From: Sarah Burrow <Sarah.Burrow@arun.gov.uk>
Sent: 17 March 2021 10:20
To: Planning.Responses <Planning.Responses@arun.gov.uk>
Cc: Finlay Gardner <Finlay.Gardner@arun.gov.uk>
Subject: RE: Planning Consultation on: M/20/21/DOC

This application follows on from a previous DOC application (M/90/20/DOC) which was refused with advice provided as to the requirements for a future DOC submission. I have lifted any outstanding comments and supplied further comments in red for the sake of continuity.

Application No: M/20/21/DOC
Registered: 17th February 2021
Site Address: 8 West Drive Middleton on Sea PO22 7TS
Description of Works: Approval of details reserved by condition imposed under ref M/48/19/HH relating to Condition No 3 - surface water drainage.

Project Number	S19988	Produced by	Mark Henly
Client	Tim Murray	Checked by	
Site Name	8 West Drive, Middleton-on-Sea		
Location	PO22 7TS	Date	03/02/2021

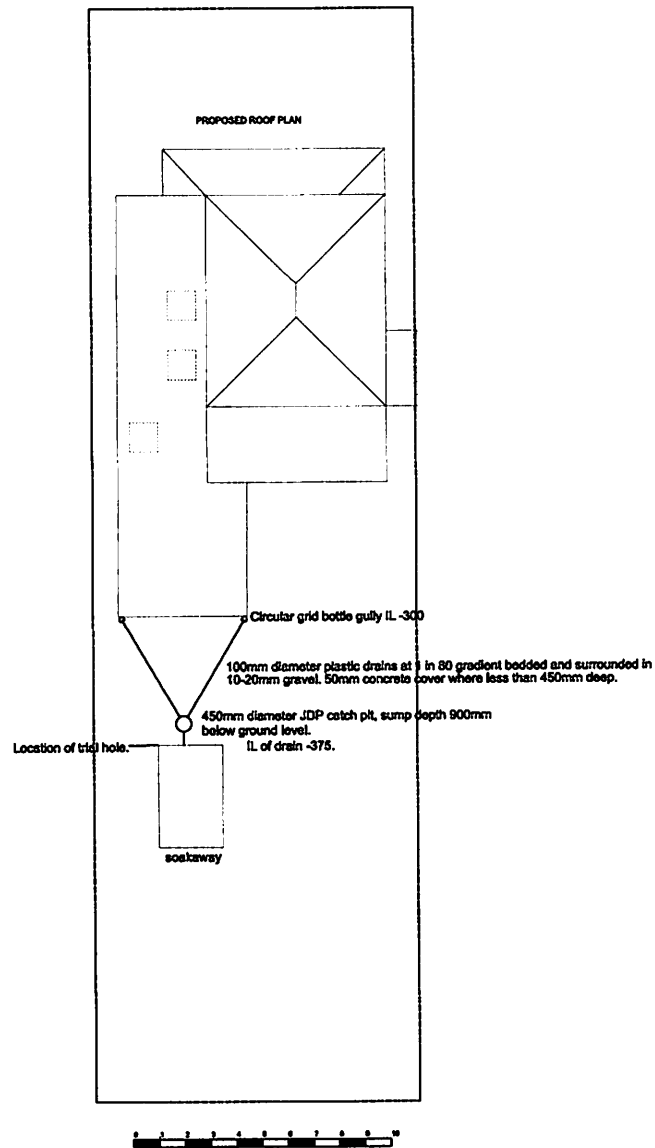
3. Calculations: I have run these calculations through three different models and all are showing the soakaway to be undersized for the 1 in 100 year +40% event. I believe that this is because the 40% climate change has been applied to the impermeable area instead of the rainfall data. The soakaway depth is also considerably shallower than the infiltration test depth, please make the soakaway deeper to correspond with the infiltration test depth.

DRG. No : Typical Soakaway Detail
With 250mm Ø Silt Trap

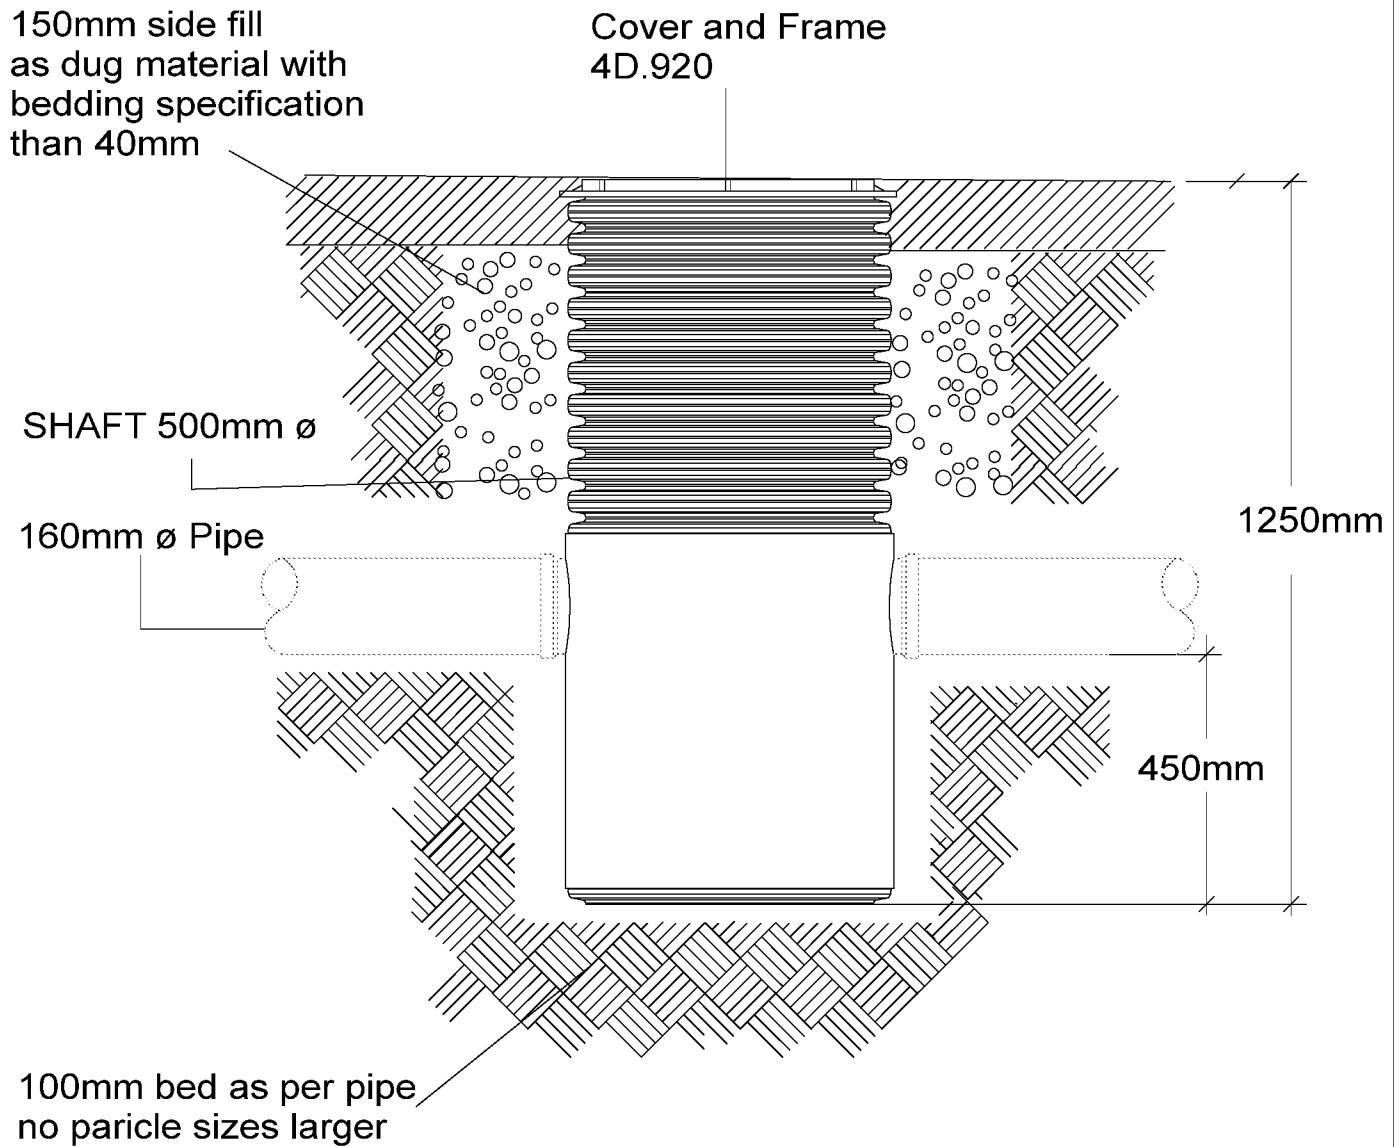
2. Please supply construction detail drawings, these have been requested on every consultation response. (Pipe bed and surround, infiltrating structures and catch-pits/silt traps).

DRAWING: SCALE	1/100
DRAWN: T. Murray	DATE: AUGUST 2018
DRAWING: 18/44/3	REVISION:

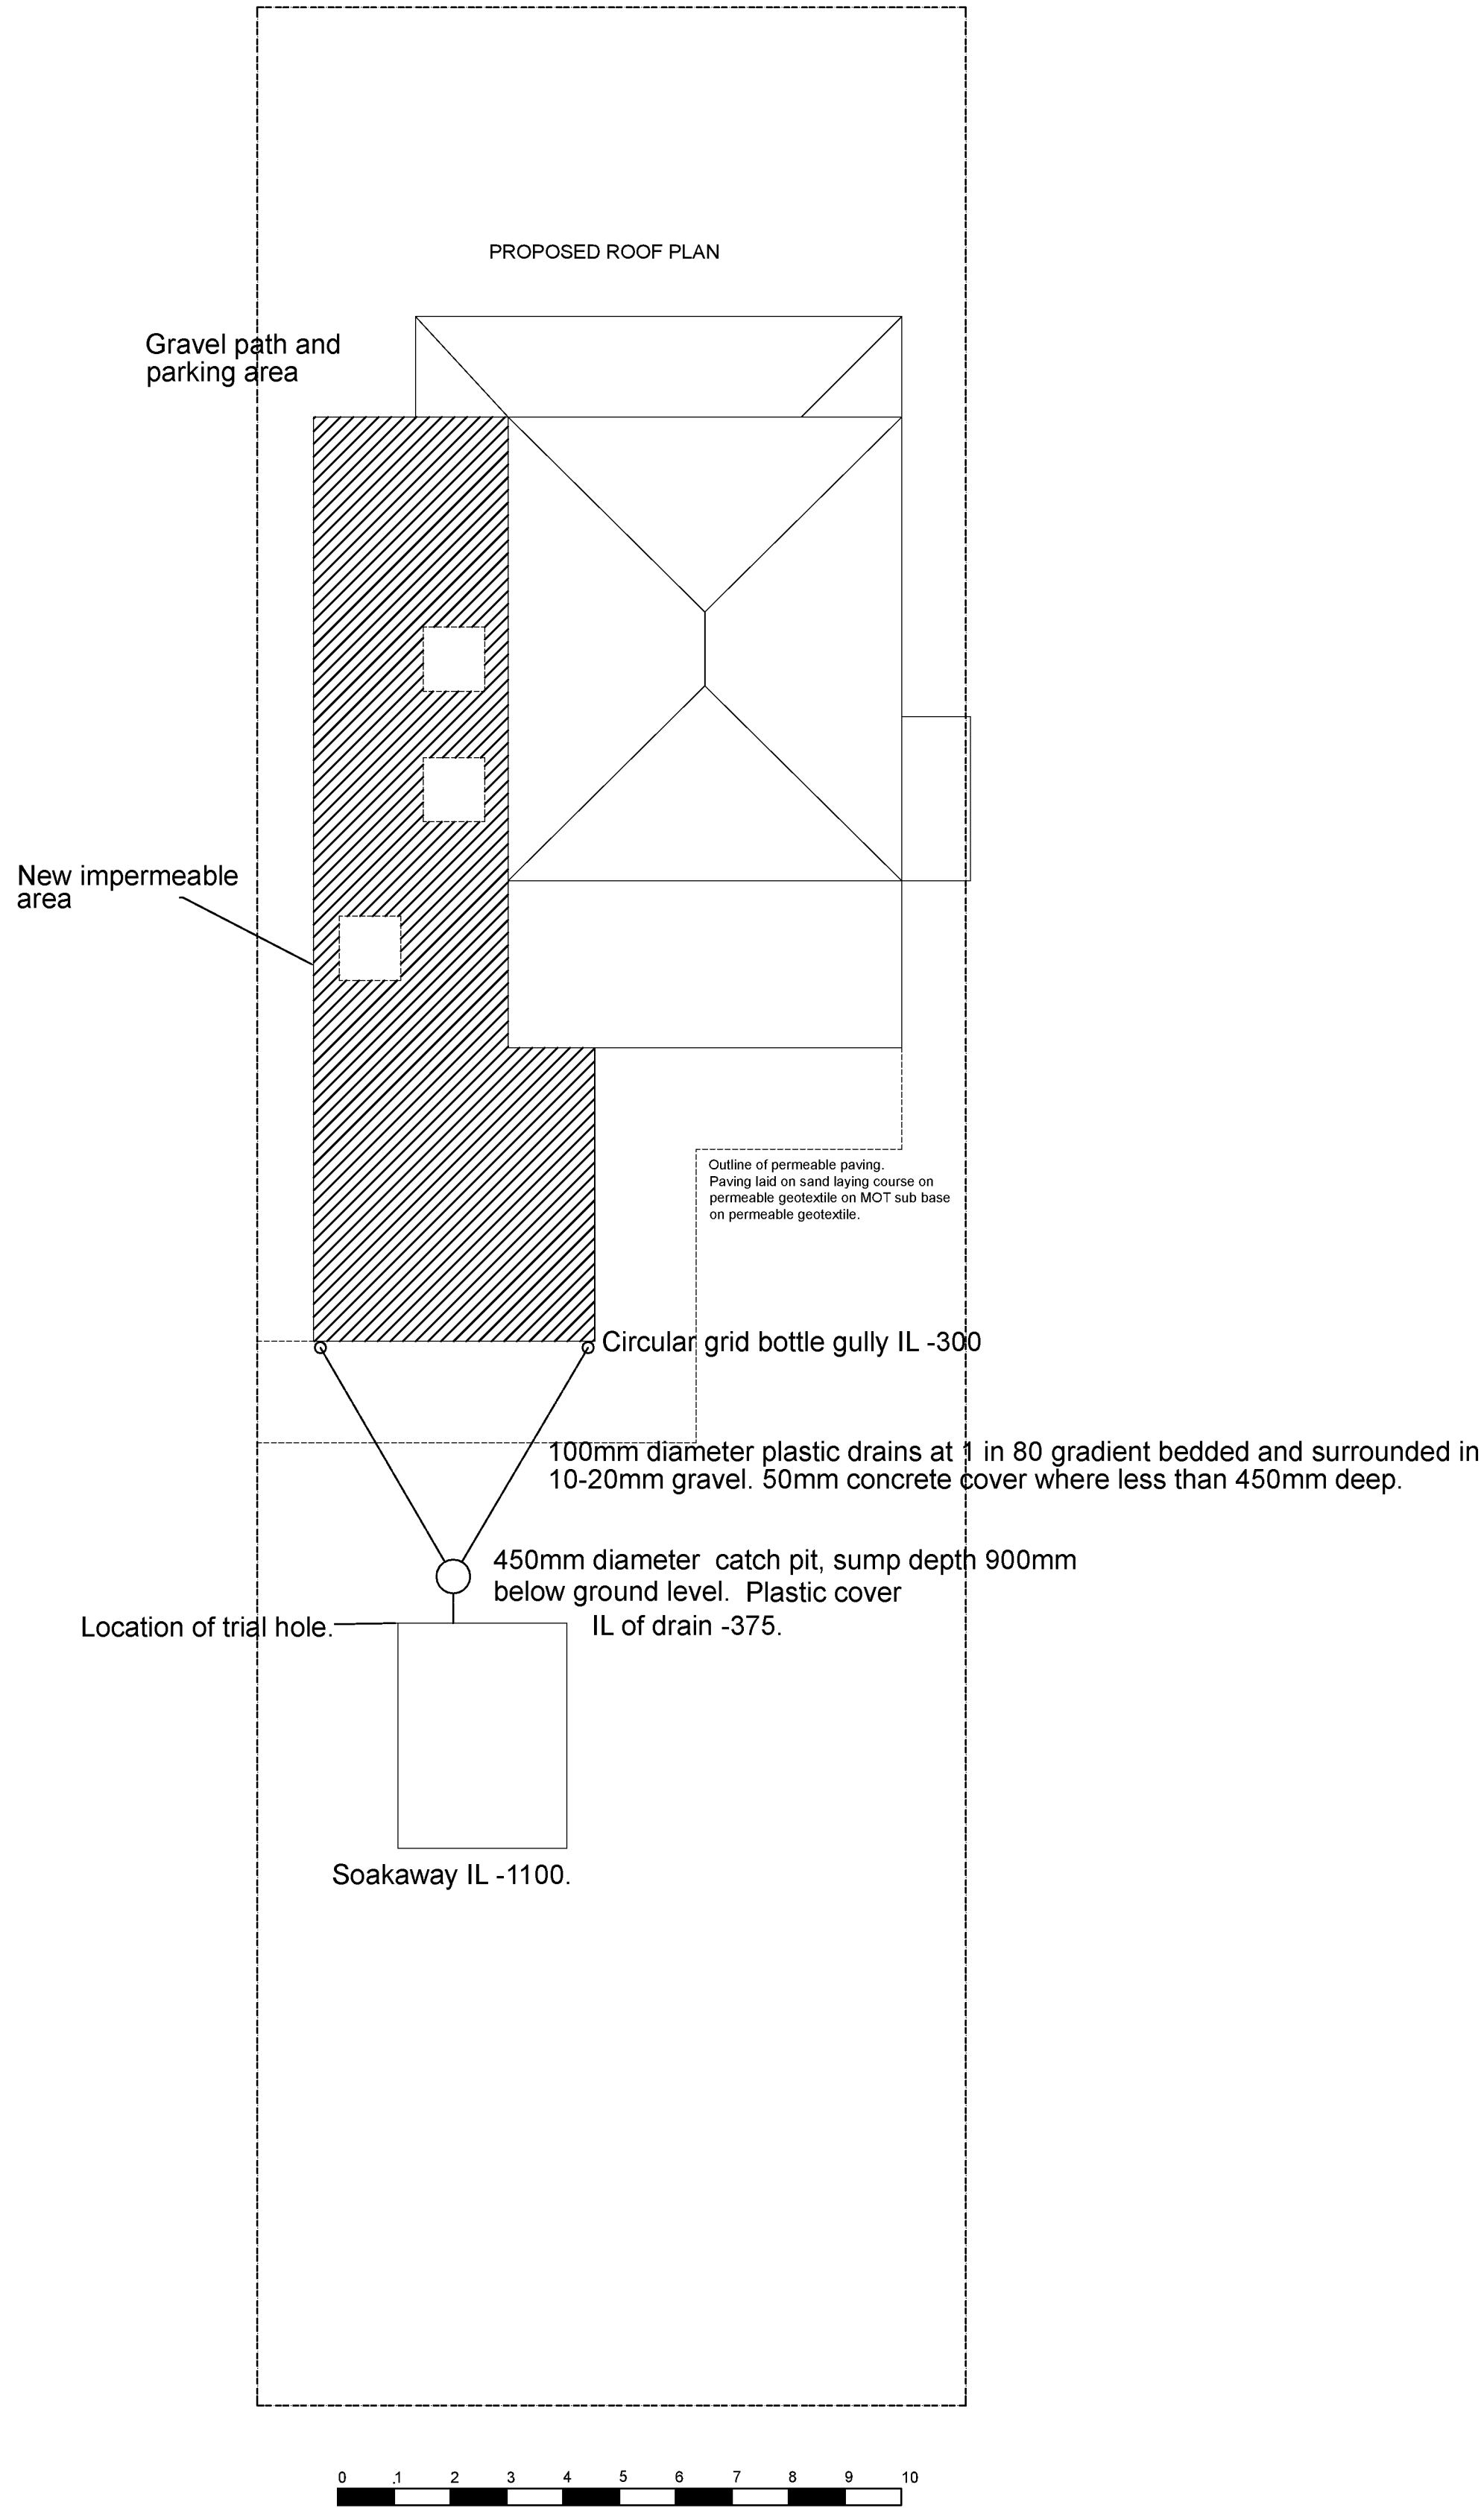
4. Drainage Layout: Guidance note 10 on the Drainage Checklist details what is required. The following points are still outstanding.

- a. All infiltrating and attenuating structures (including permeable paving) labelled with; dimensions, invert and cover levels.
- b. All manholes labelled with; ~~cover levels, invert levels~~, cover types detailed. Cover type not listed, this may be included with construction detail drawings.

5. An impermeable area plan – in this case the additional impermeable area can be marked on the drainage layout (include the square meterage used for the calculations). Not done.
